**Consultation Response from KC,
Trees**

2026/90938 land at, Hanging Stone Road, Berry Brow, Huddersfield, HD4 7QU

Erection of detached dwelling (within the curtilage of a Listed Building)

Date Responded: 17/04/2026

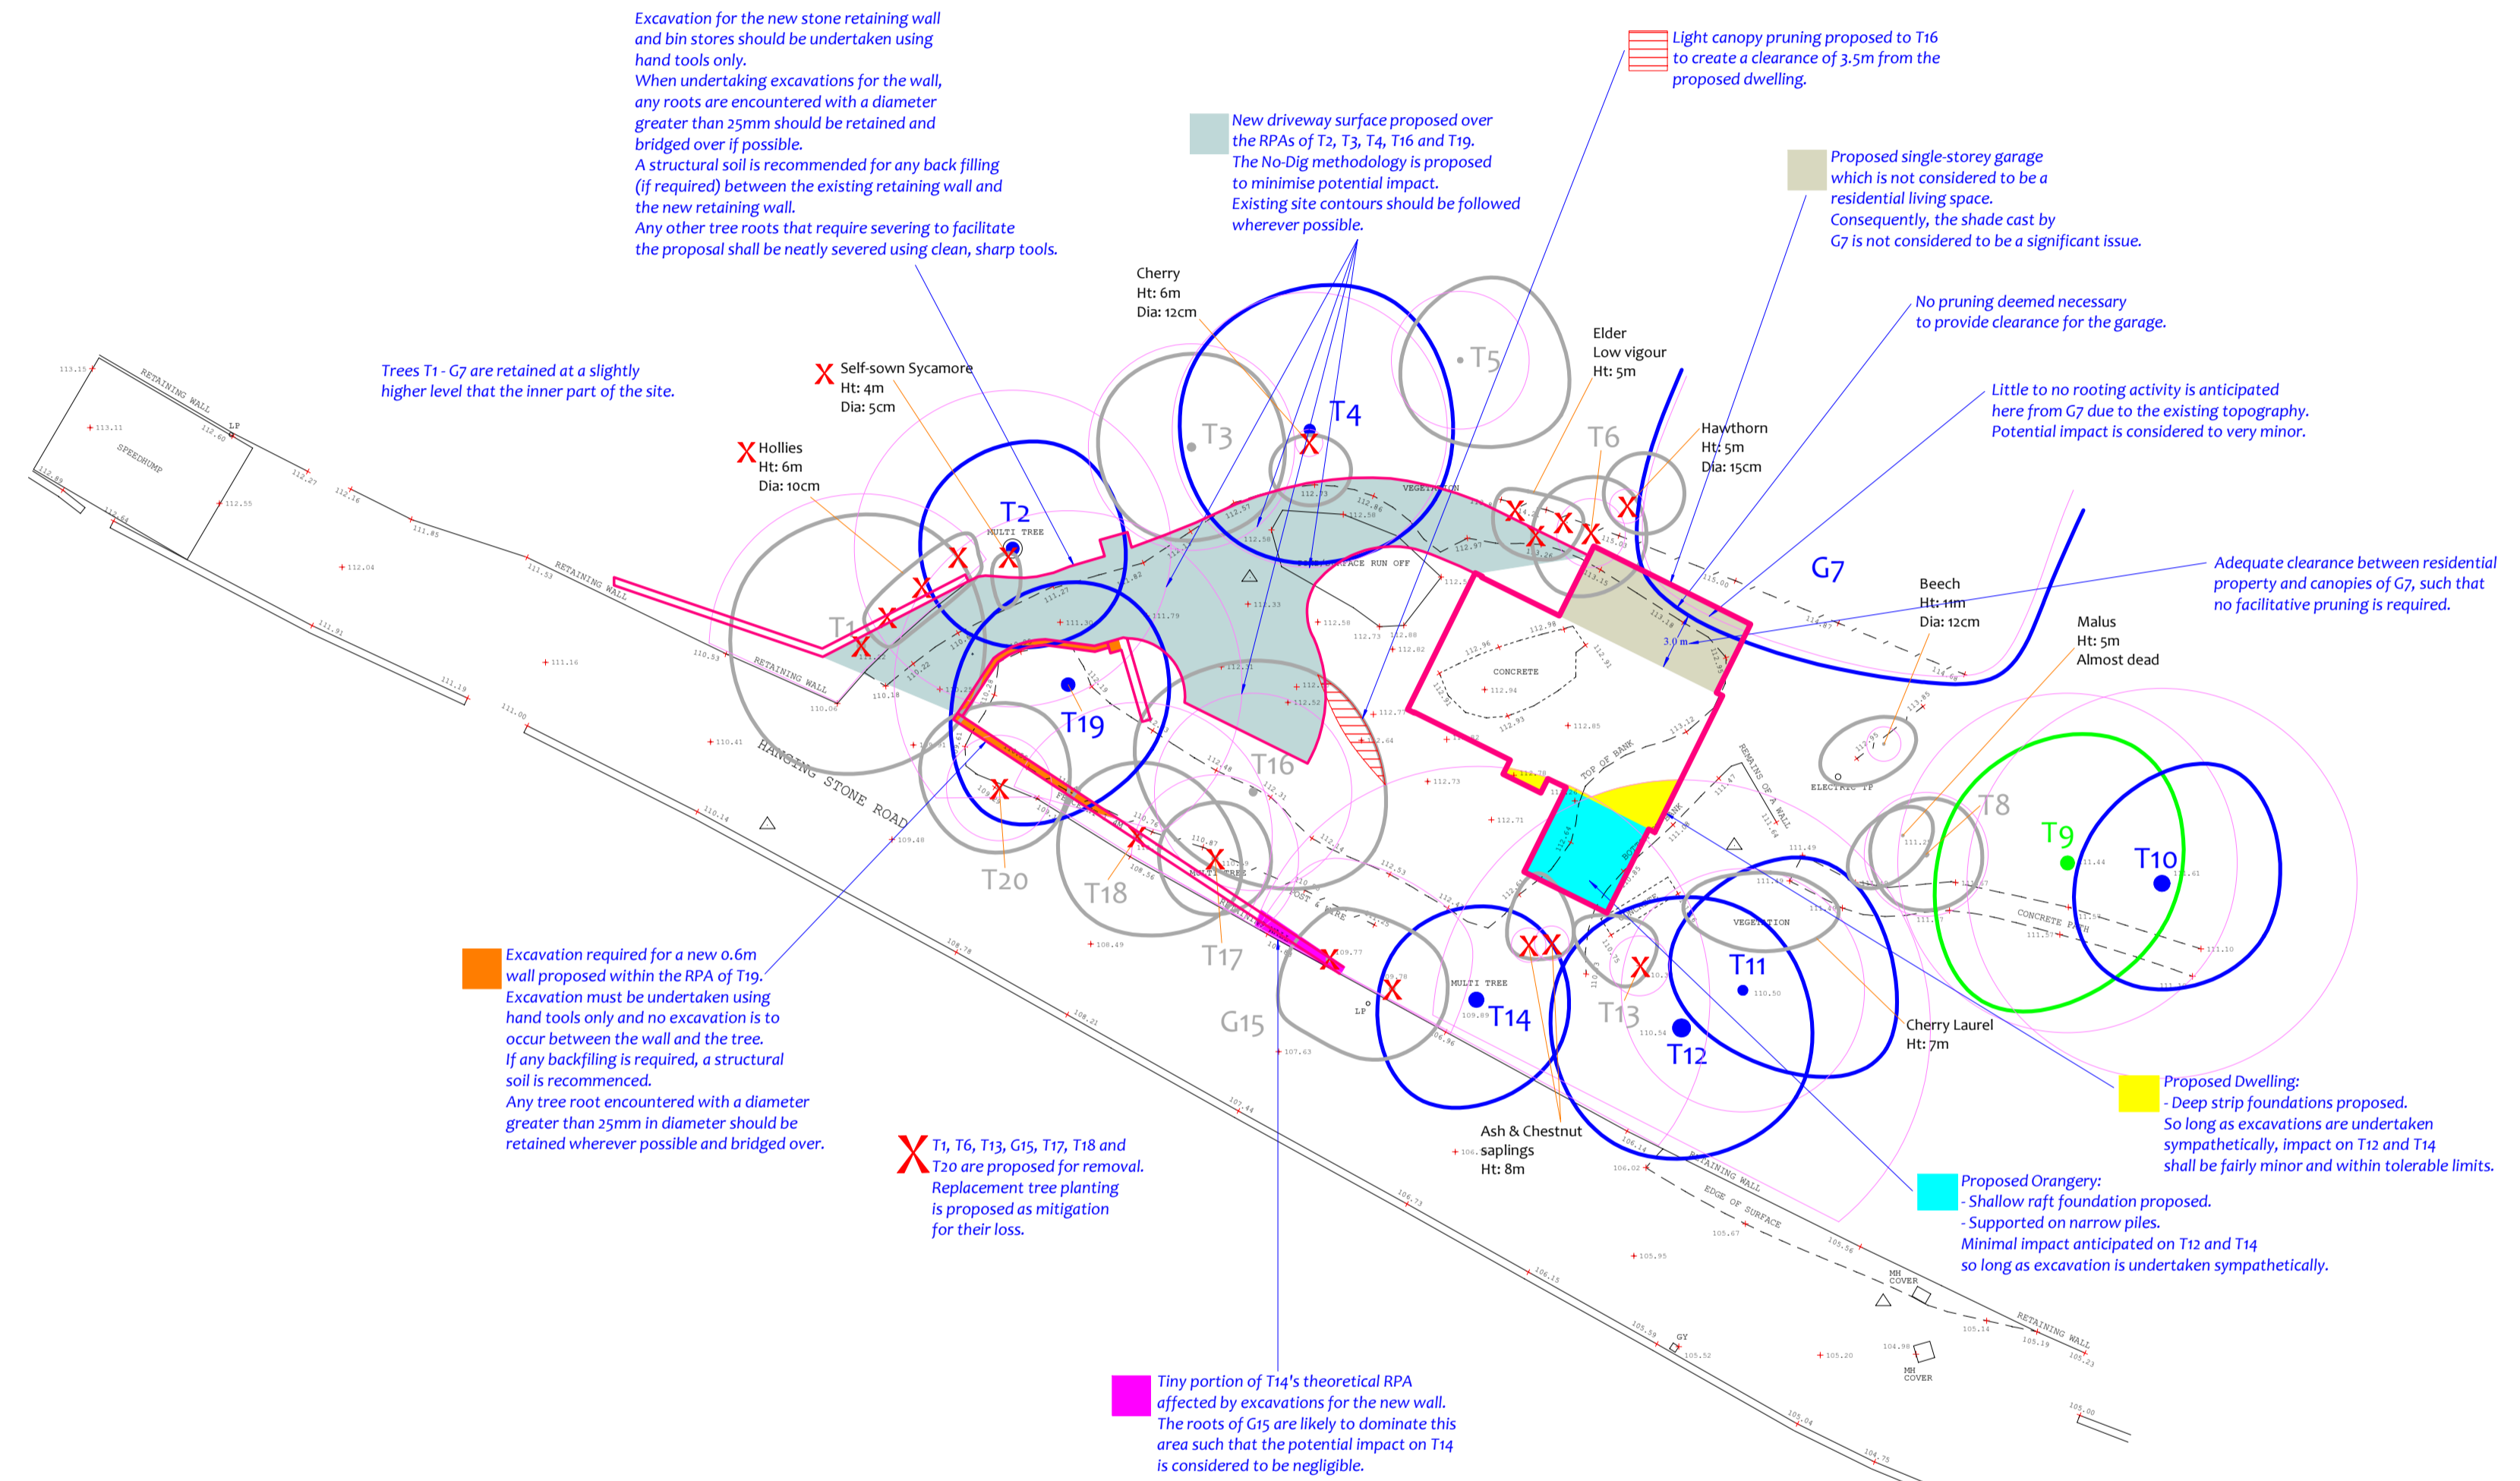
Tree T1 is protected by the above mentioned TPO and it appears that its only defect would be the presence of dead wood, which is common amongst woodlands or dense groups of trees. It's categorisation as a category C tree appears unjust and without further evidence to display the degree of deadwood present KC trees believes the tree may warrant a higher category. Its removal is proposed purely to facilitate the access road which, given its protection and lack of Arboricultural reasons for removal, KC trees would object to its removal as it would have a direct impact on the immediate landscape.

Proposed Planting Plan

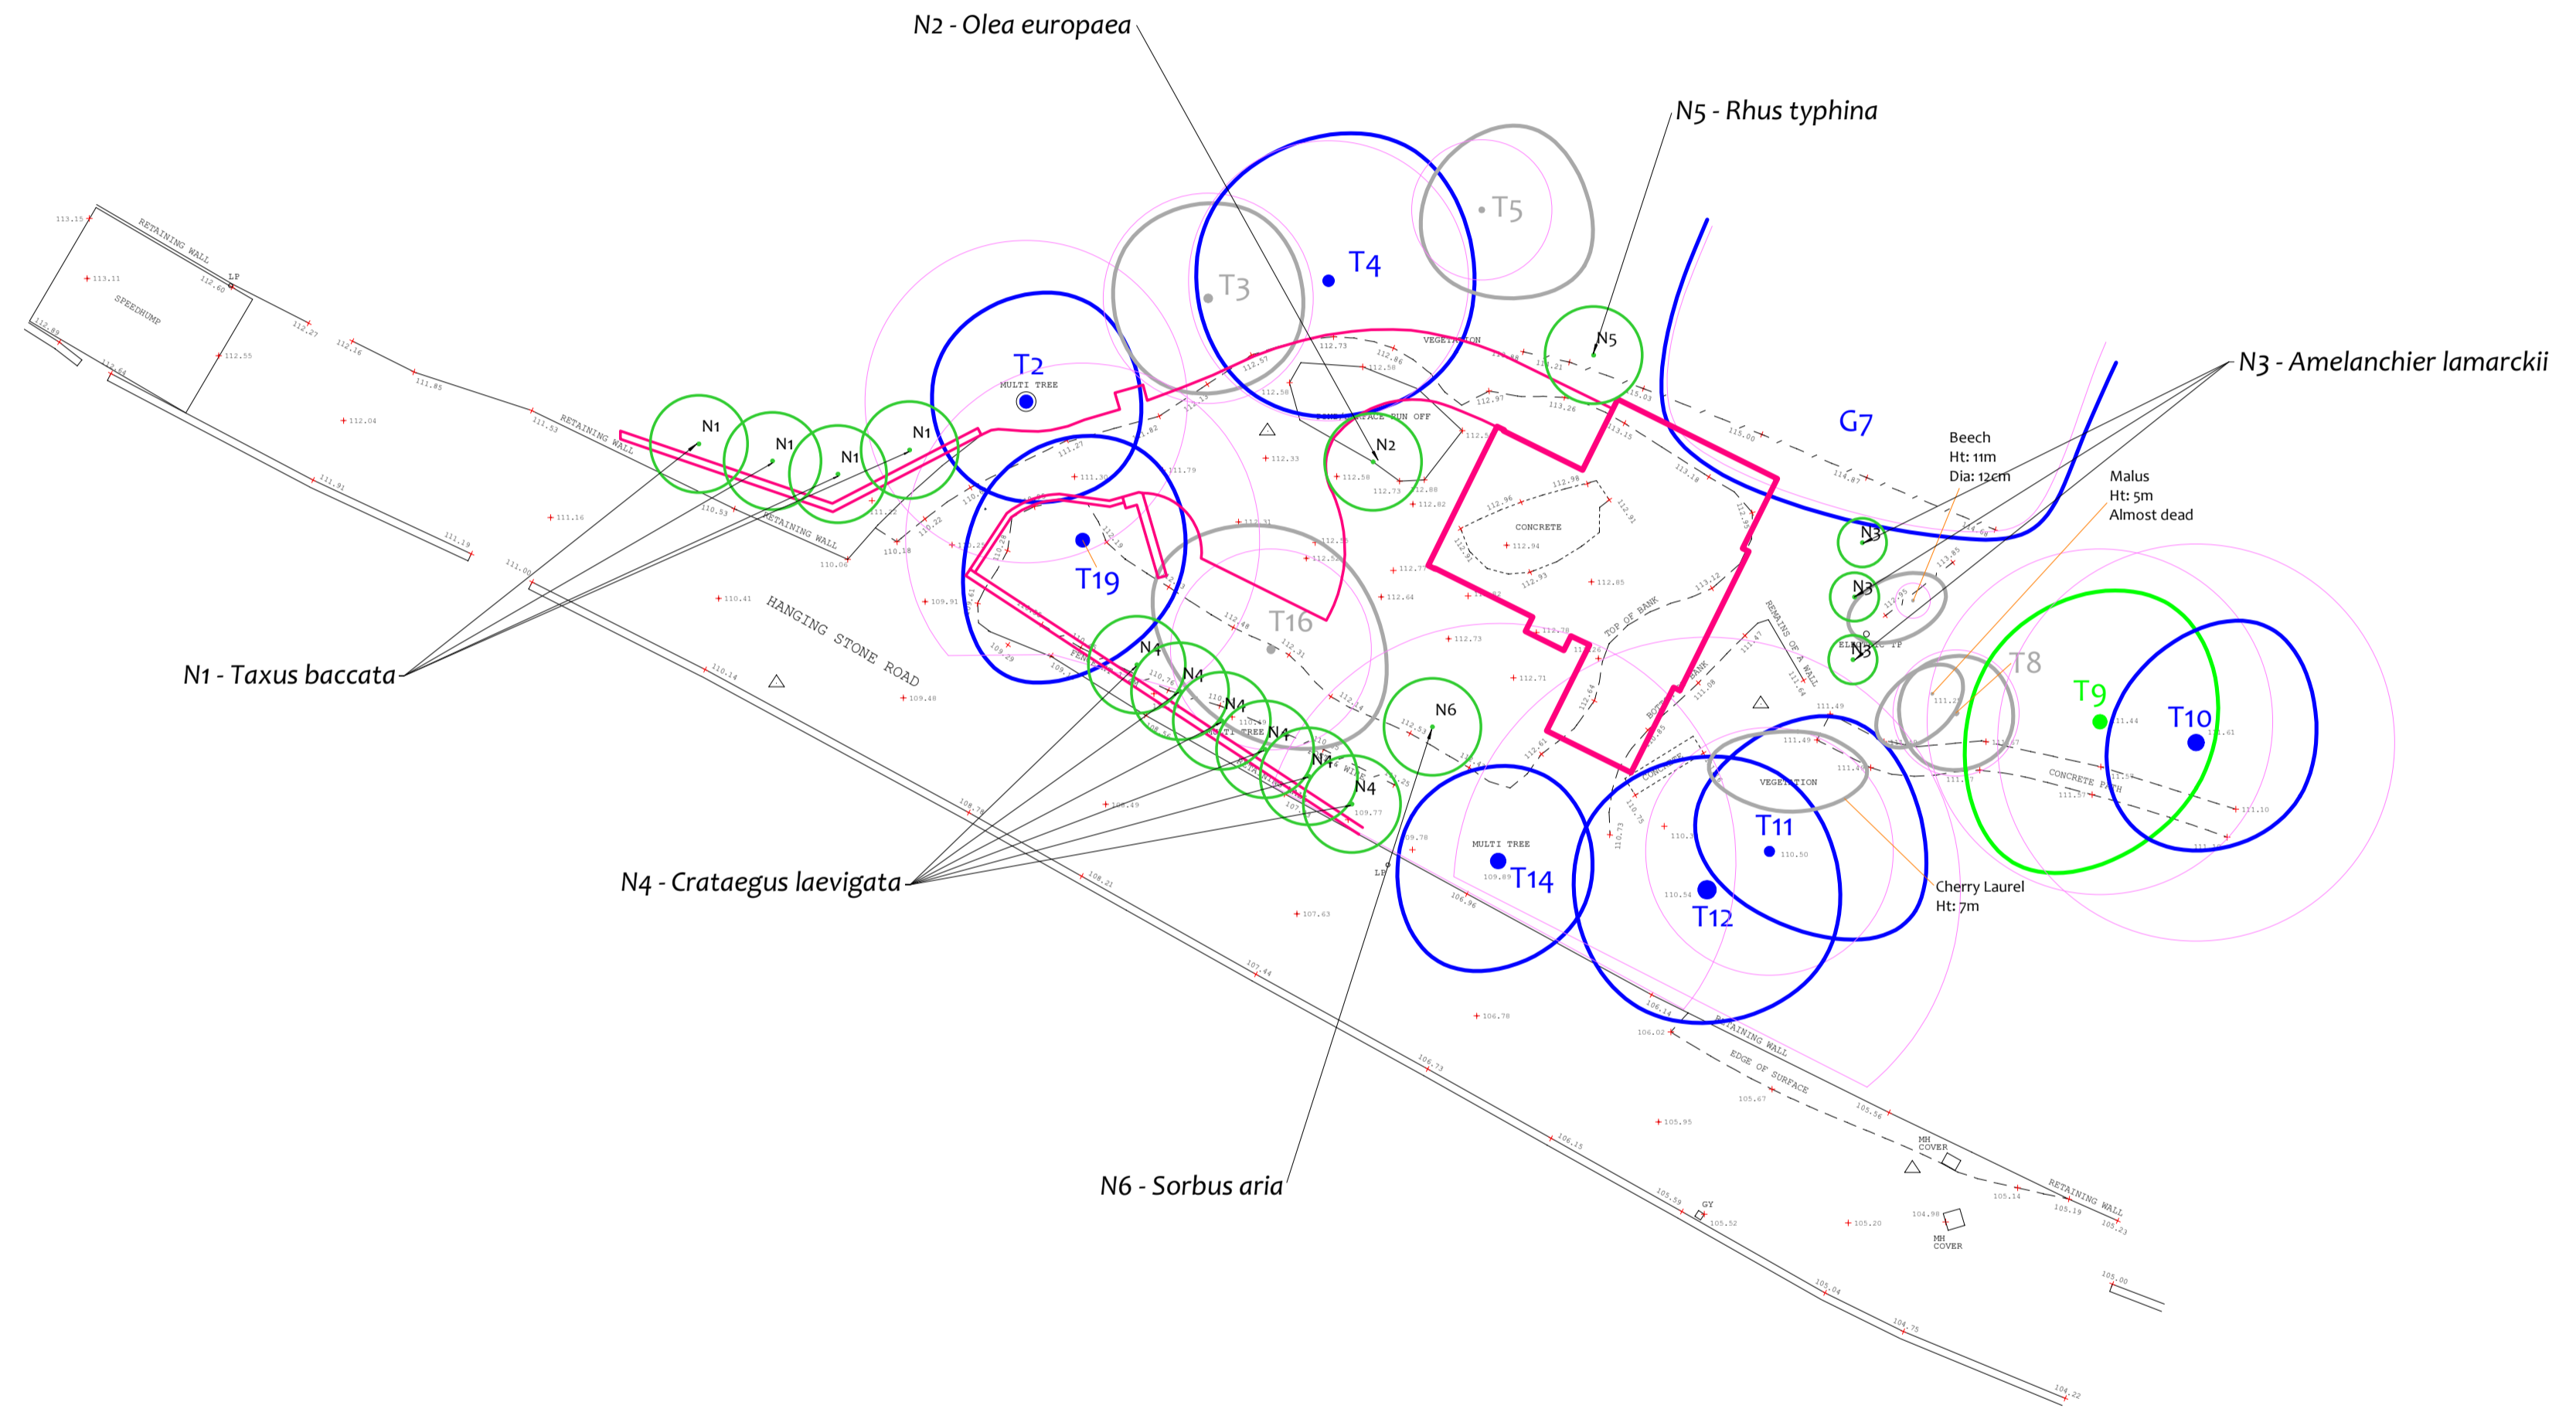
The proposed building of retaining walls to the north and south of the access driveway runs directly through multiple trees root protection areas. Even though hand dig techniques have been recommended KC trees is of the opinion that the amount and size of the roots encountered will be significant and all roots above 25mm in diameter which would be retained would in fact make the retaining walls and proposed driveway unachievable. Any root pruning would have a direct impact on the trees ability to source water and nutrients whilst creating pruning wounds which are susceptible to infection.

The house and orangery are situated directly North of 3 large, mature trees. The suggested pile and raft foundations of the orangery in theory may be achievable with some investigation into the location of large tree roots. However, the entire purpose of an orangery is to allow an abundance of light to flood the room which will be impossible due to the location of the large trees to the south. This would create an indirect threat to have these trees removed due to them continually shading the room whilst dropping detritus on its roof for a large portion of the year.
